Our ref.: MP06\_0025 MOD 5

**Stage 1 Vincentia Town Centre, Vincentia (MP06\_0025 MOD 5)  
Response to Submissions**

## Attachment 1

19m ARTICULATED VEHICLE SWEEP PATHS

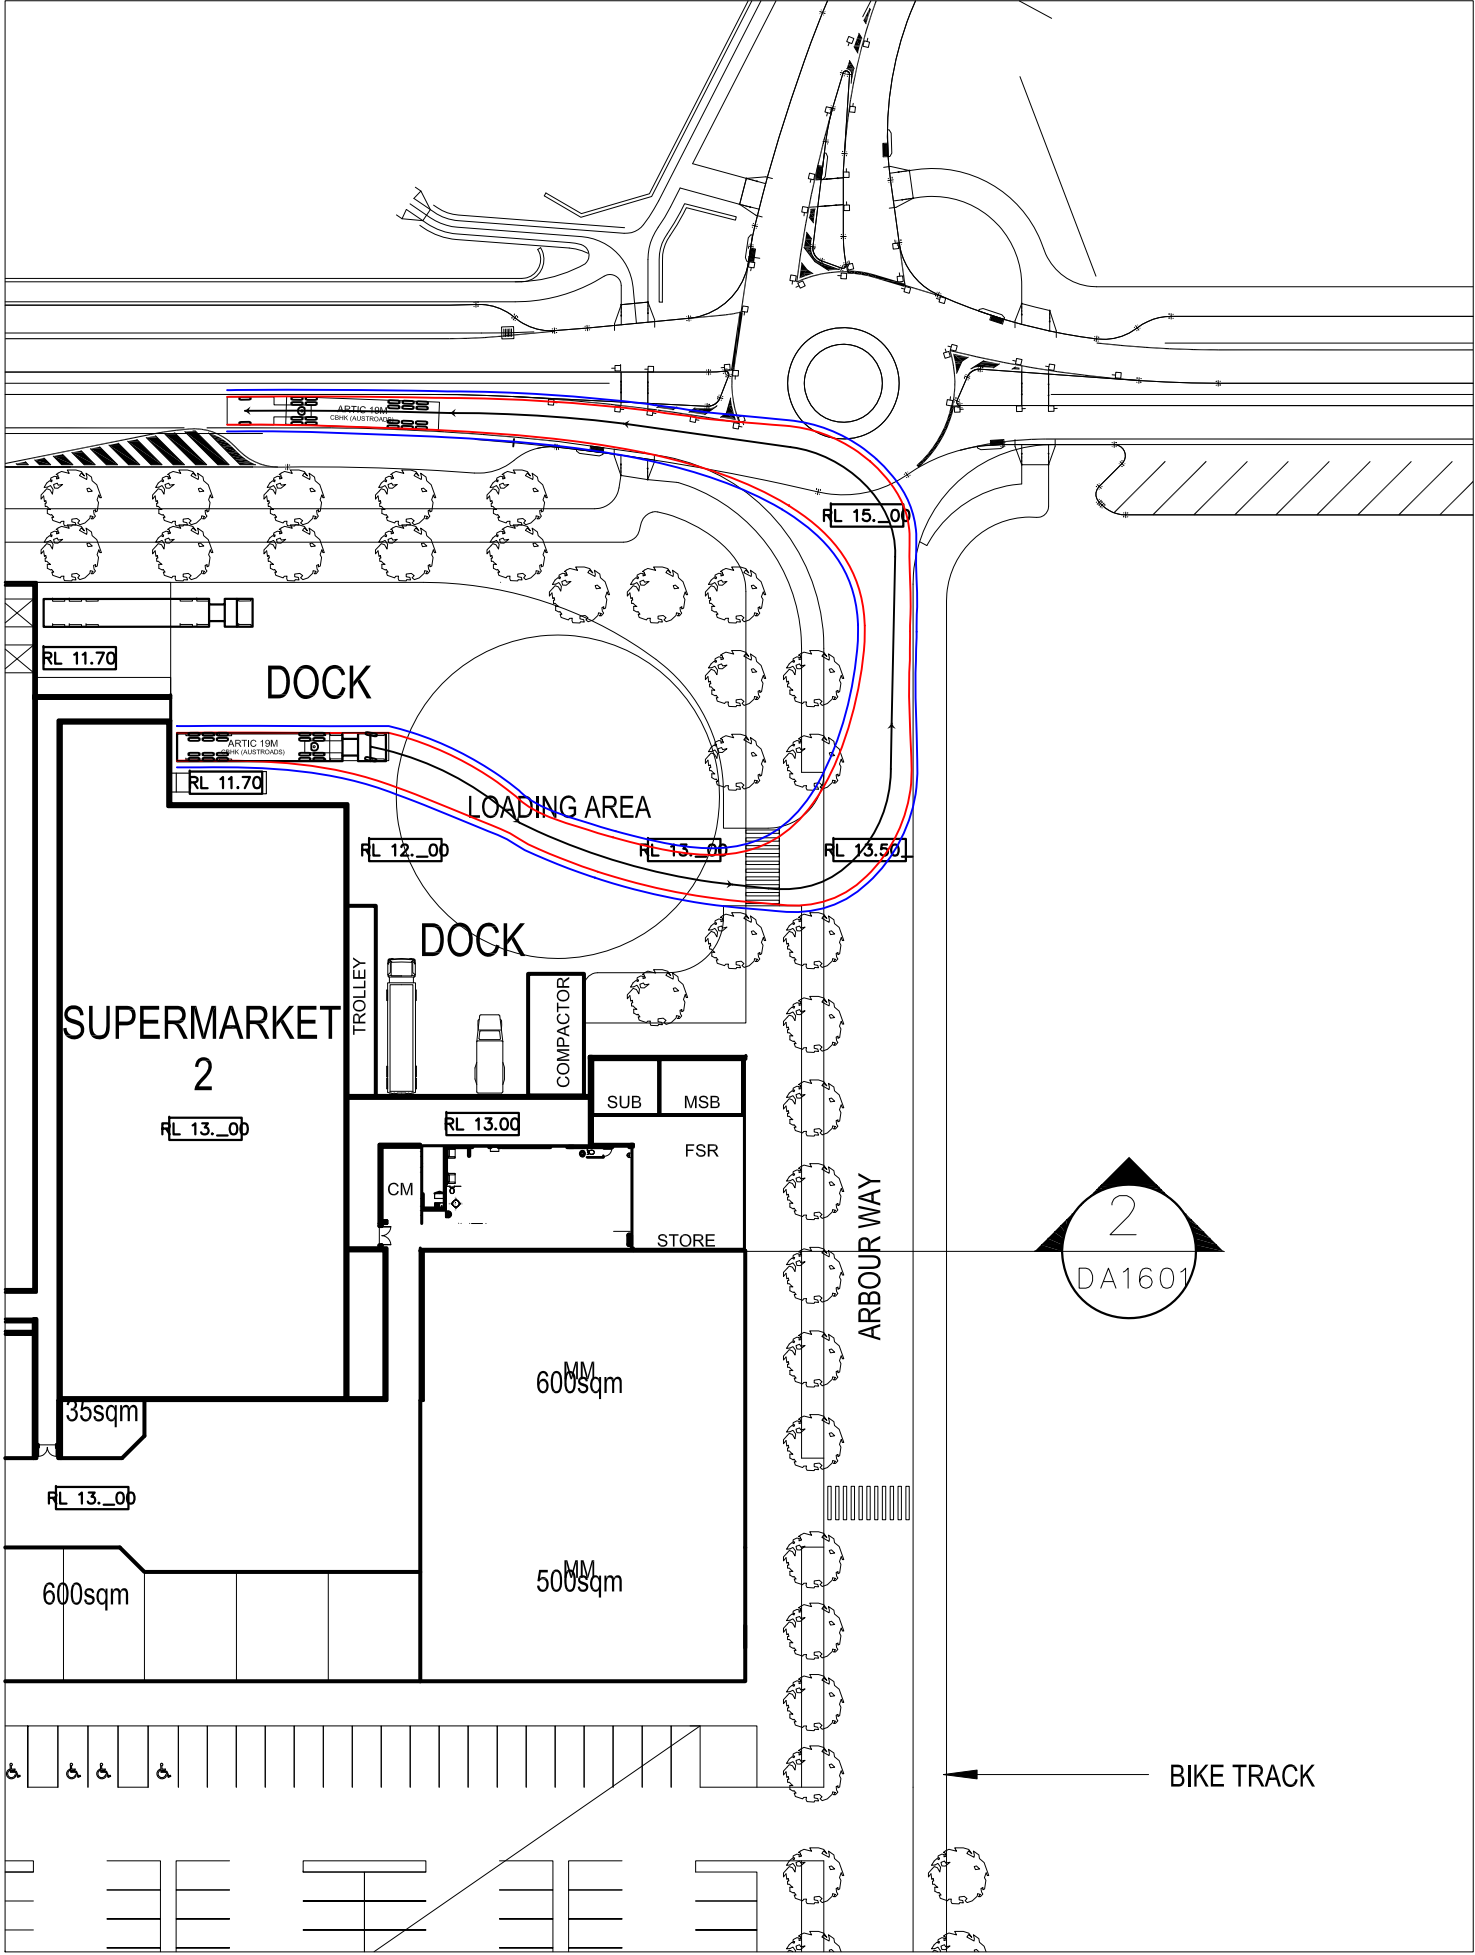
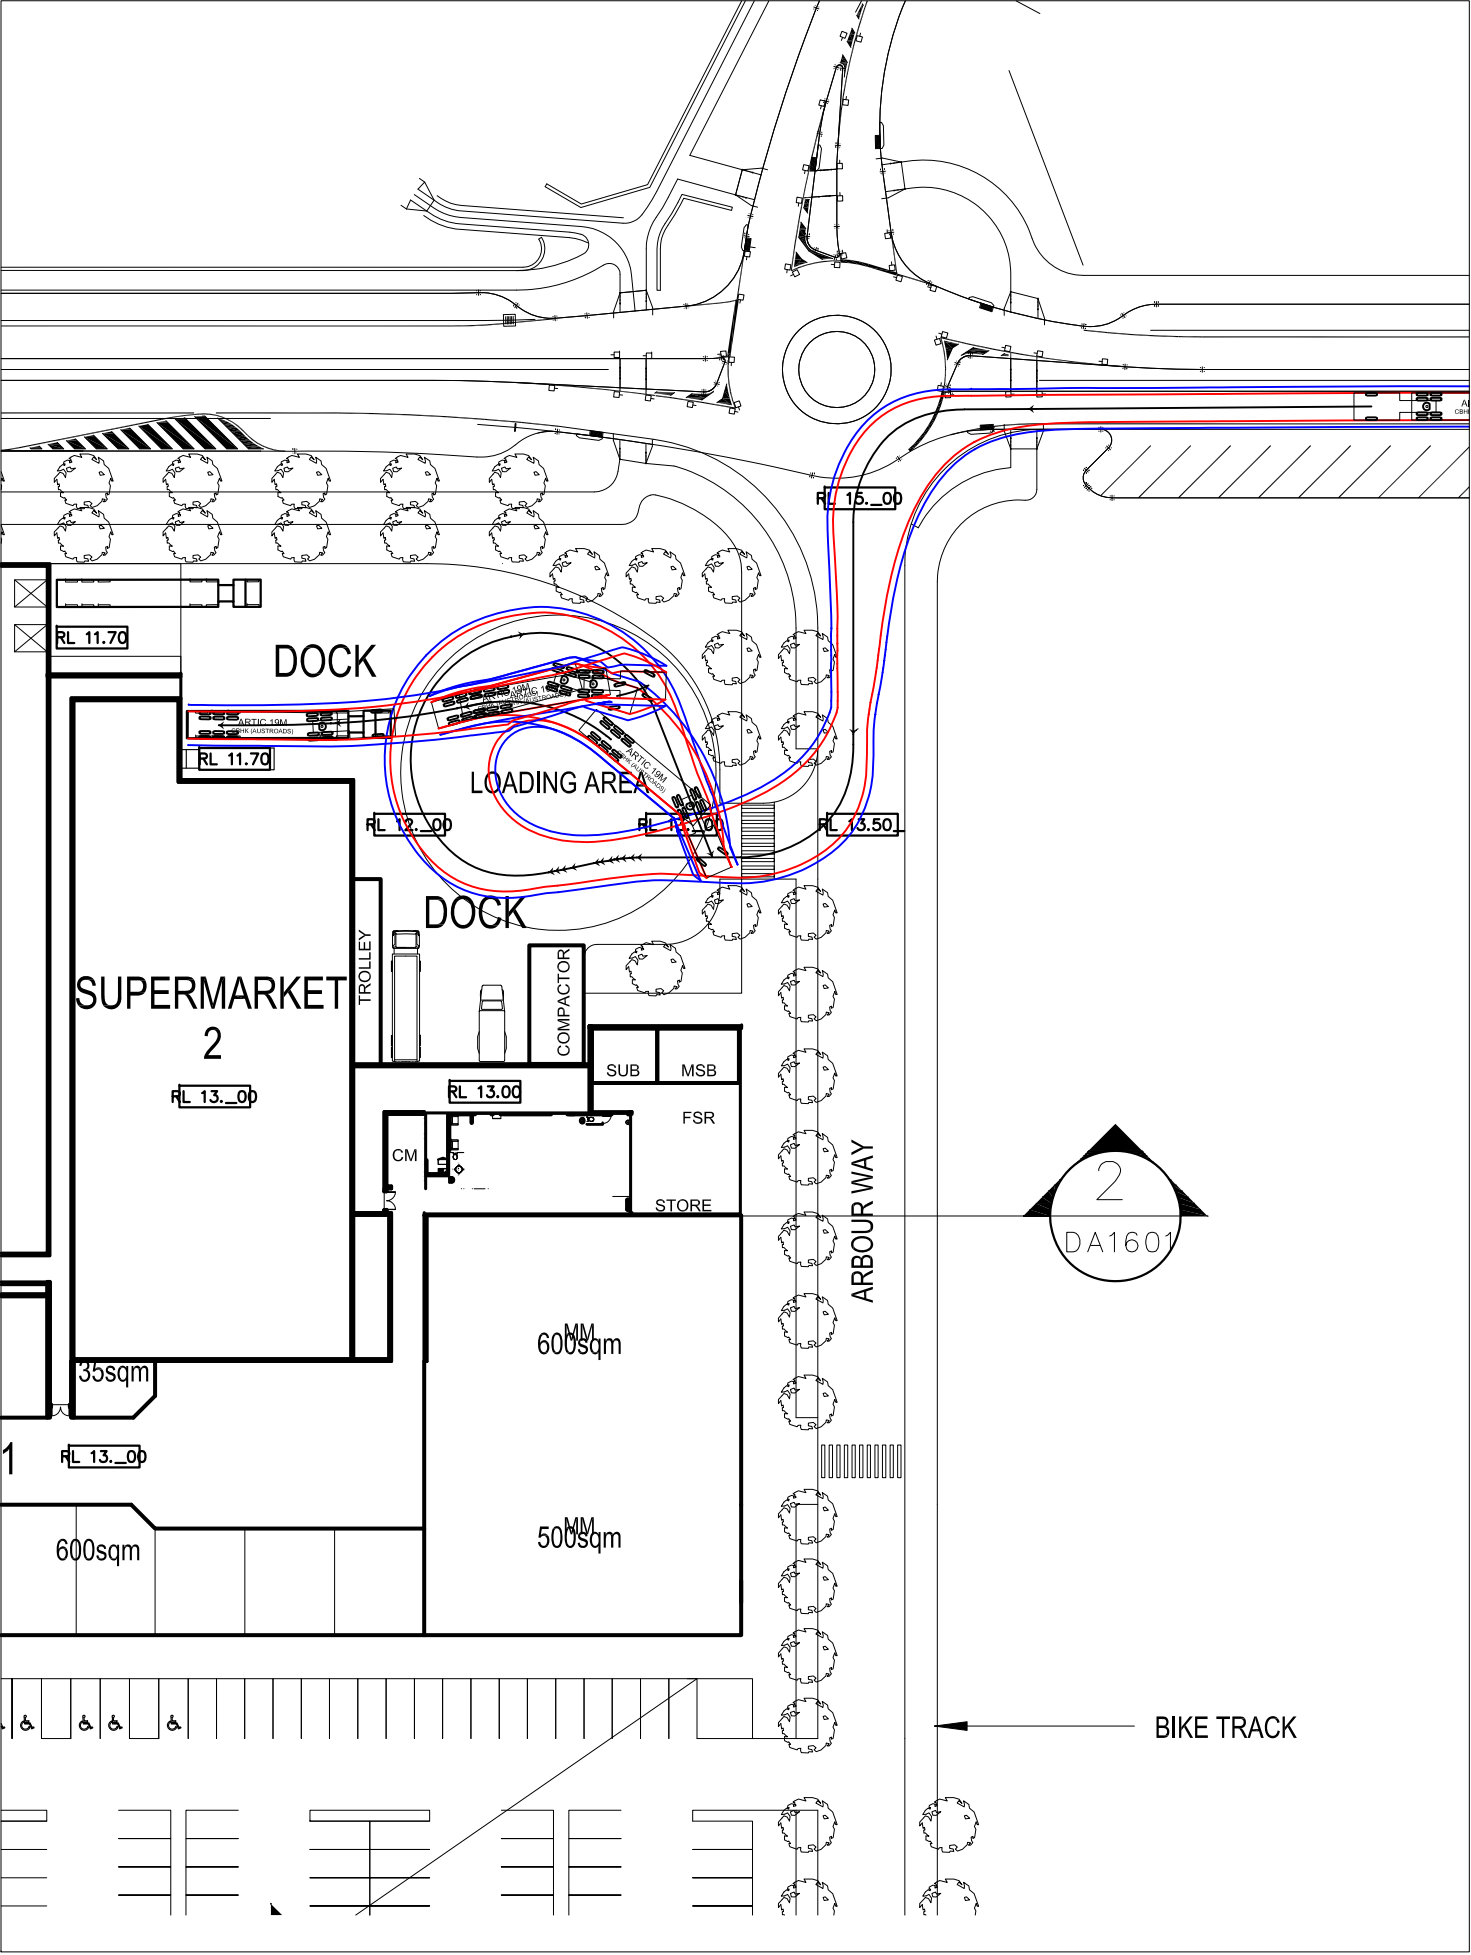
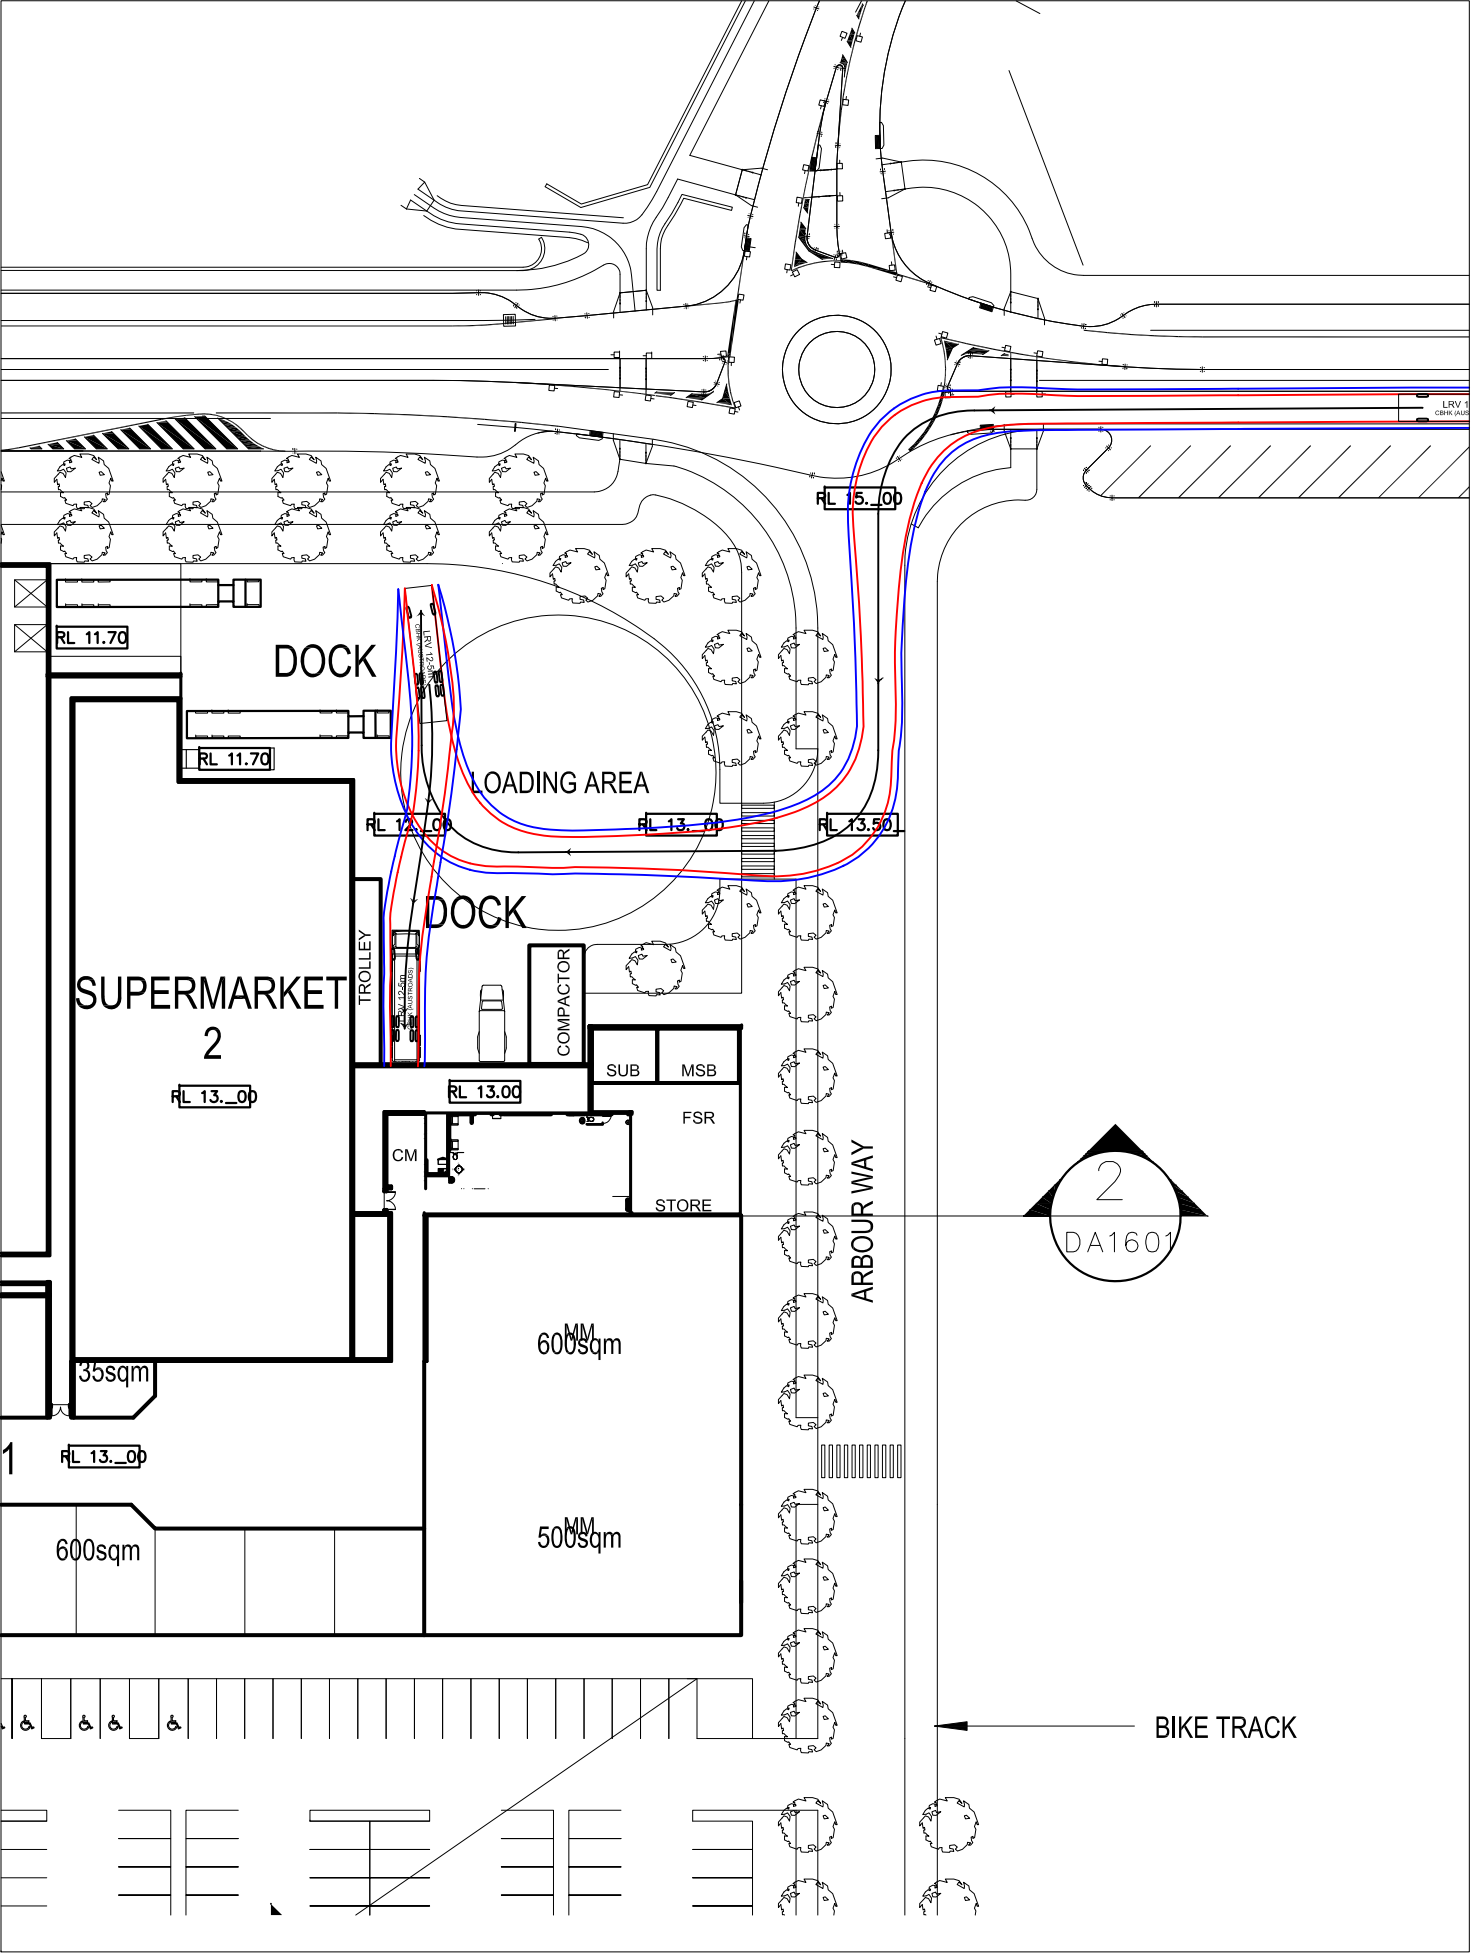
- The proposed use of Arbour Way as the main pedestrian spine into the centre, conflicts with the need to provide clear and unobstructed access to the loading dock and vehicular access to the car park. Consideration should be given to an alternate loading / unloading arrangement (including relocation options using the western road access off Moona Creek Road) to minimise conflicts with other vehicles / pedestrians.

- need for details of road reserve dimensions at the proposed roundabout at Halloran Road and MCR are required not encroaching outside the site;
- need for details on the usage / traffic patterns at western access to car park or from internal traffic flow / queuing for fuel and fast food outlets;
- need for construction timing of MCR prior to CC for Stage 1;
- further information on the opportunity to include a taxi call system within car park; and
- need for details of swept paths for Stage 2 to validate practical use of the loading docks.
